## Department of Transportation

Traffic & Safety - Access Permits

October 3, 2024

RE: PPR2433 Site Development Plan - Monument Glamping II

MICAH JEUB
GLAMPING II
SITE DEVELOPMENT PLAN

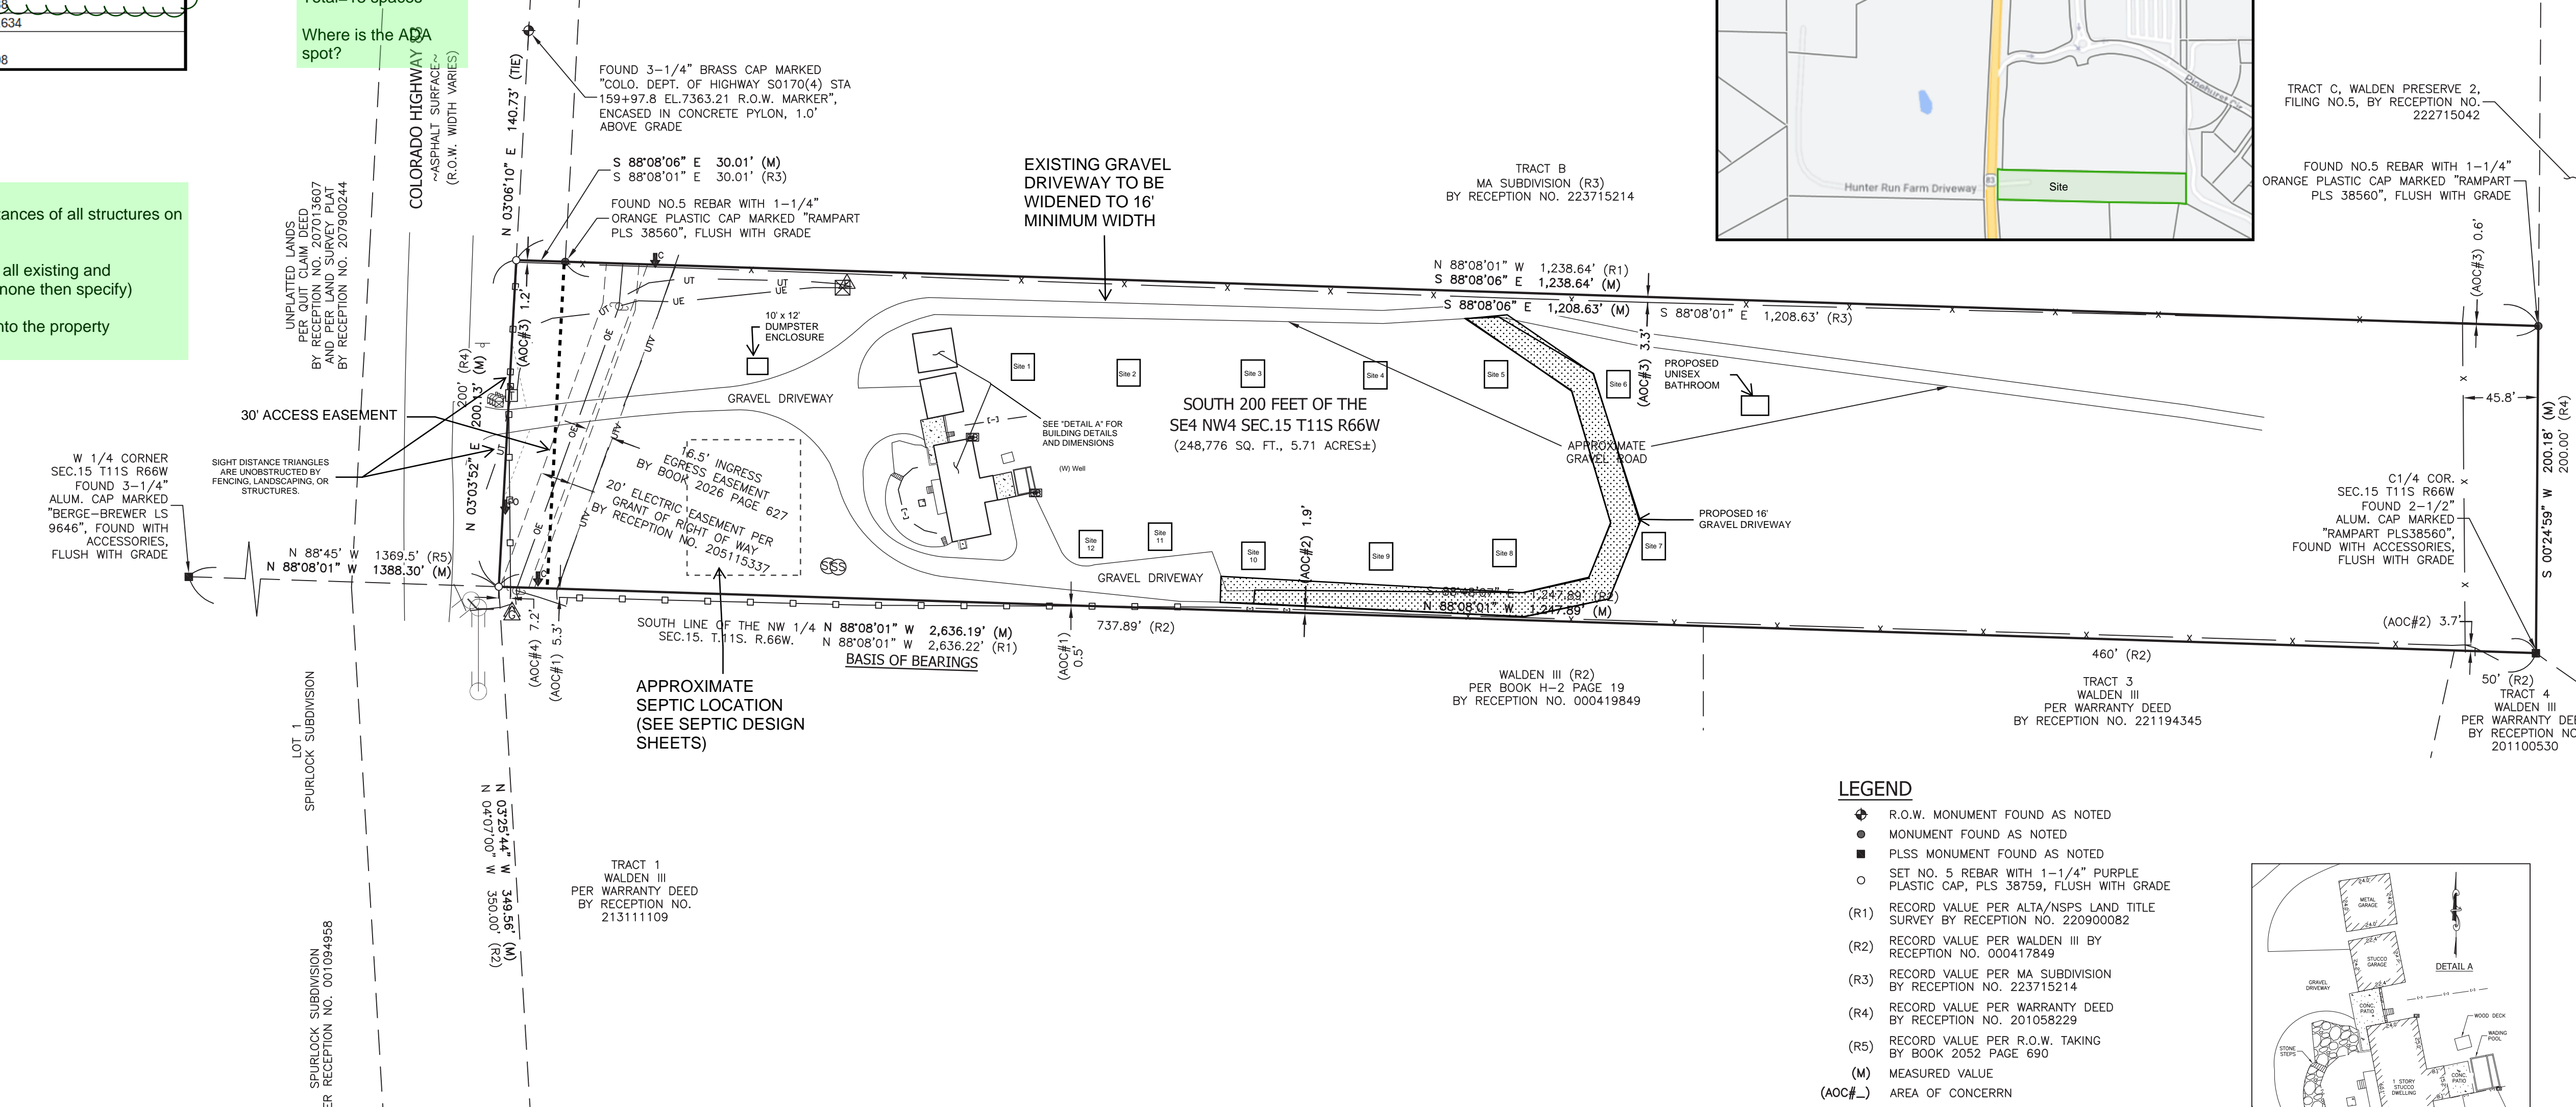
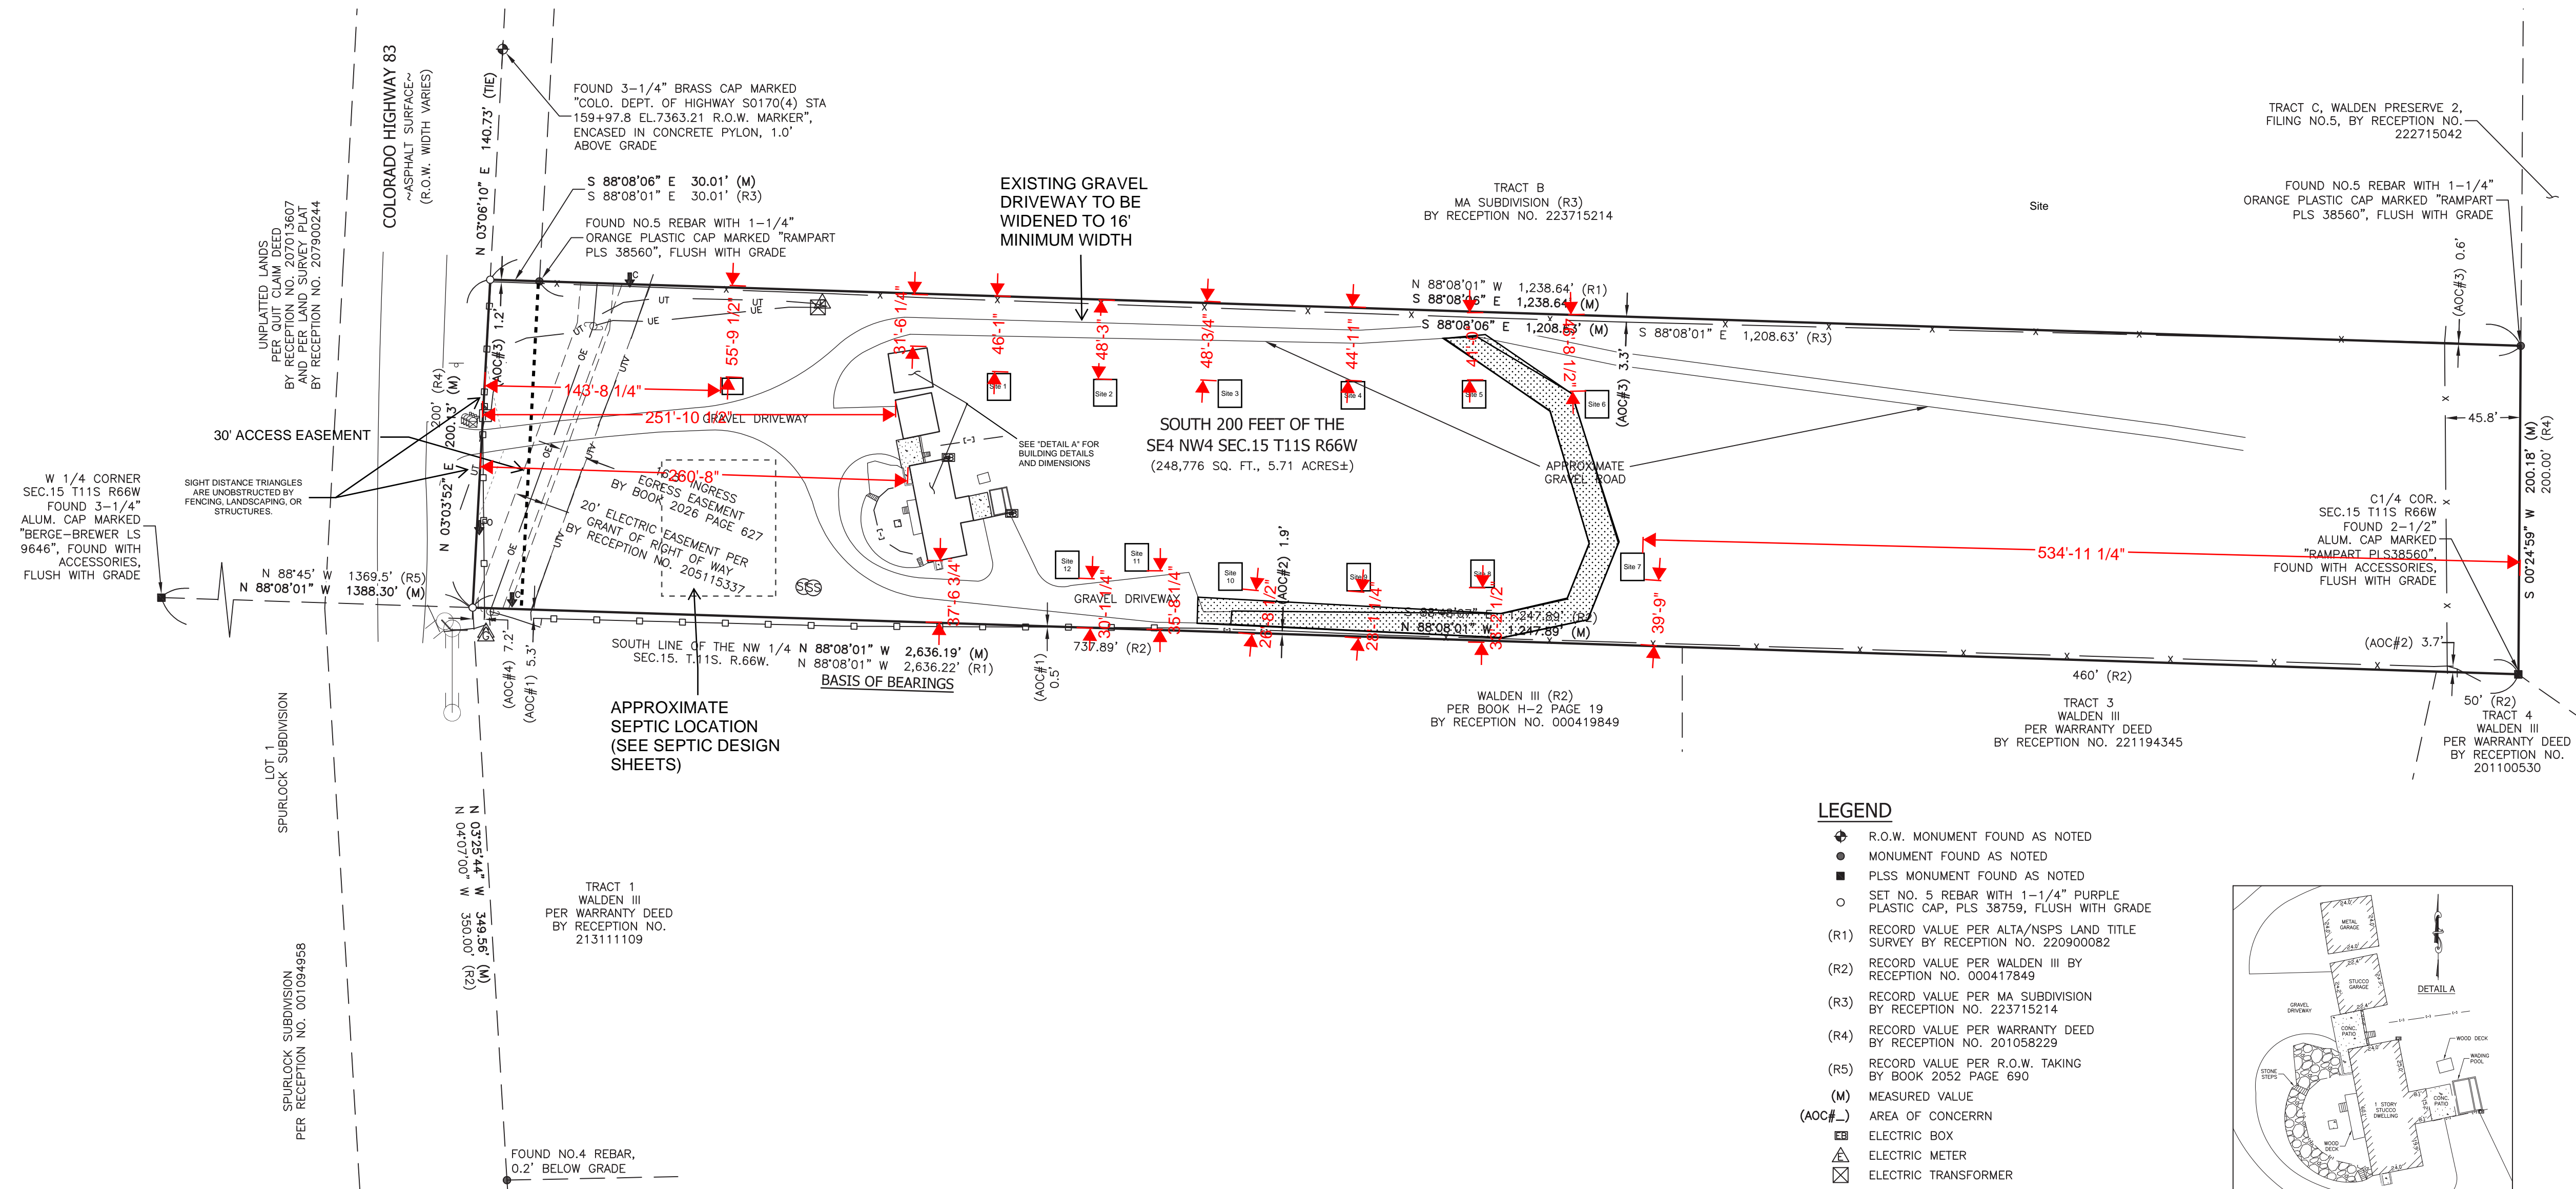
- Trip generation is acceptable.
- The intended access does not comply with the access control plan for state highway 083A. The approved plan indicates cross lot access to Walden Way.

- A CDOT Access Permit (223018) was issued in May of 2023. The Notice to Proceed has not yet been issued.
- Dedication of a 30-foot access easement parallel with state highway 083A shall be established and recorded with El Paso County before the Notice to Proceed issuance.
- See attached Exhibit D and Exhibit E of the Highway 83 Access Control Plan.
- The access will be closed in the future if a cross access easement is obtained with adjacent properties and Internal Connectivity to/from Walden Way is developed.
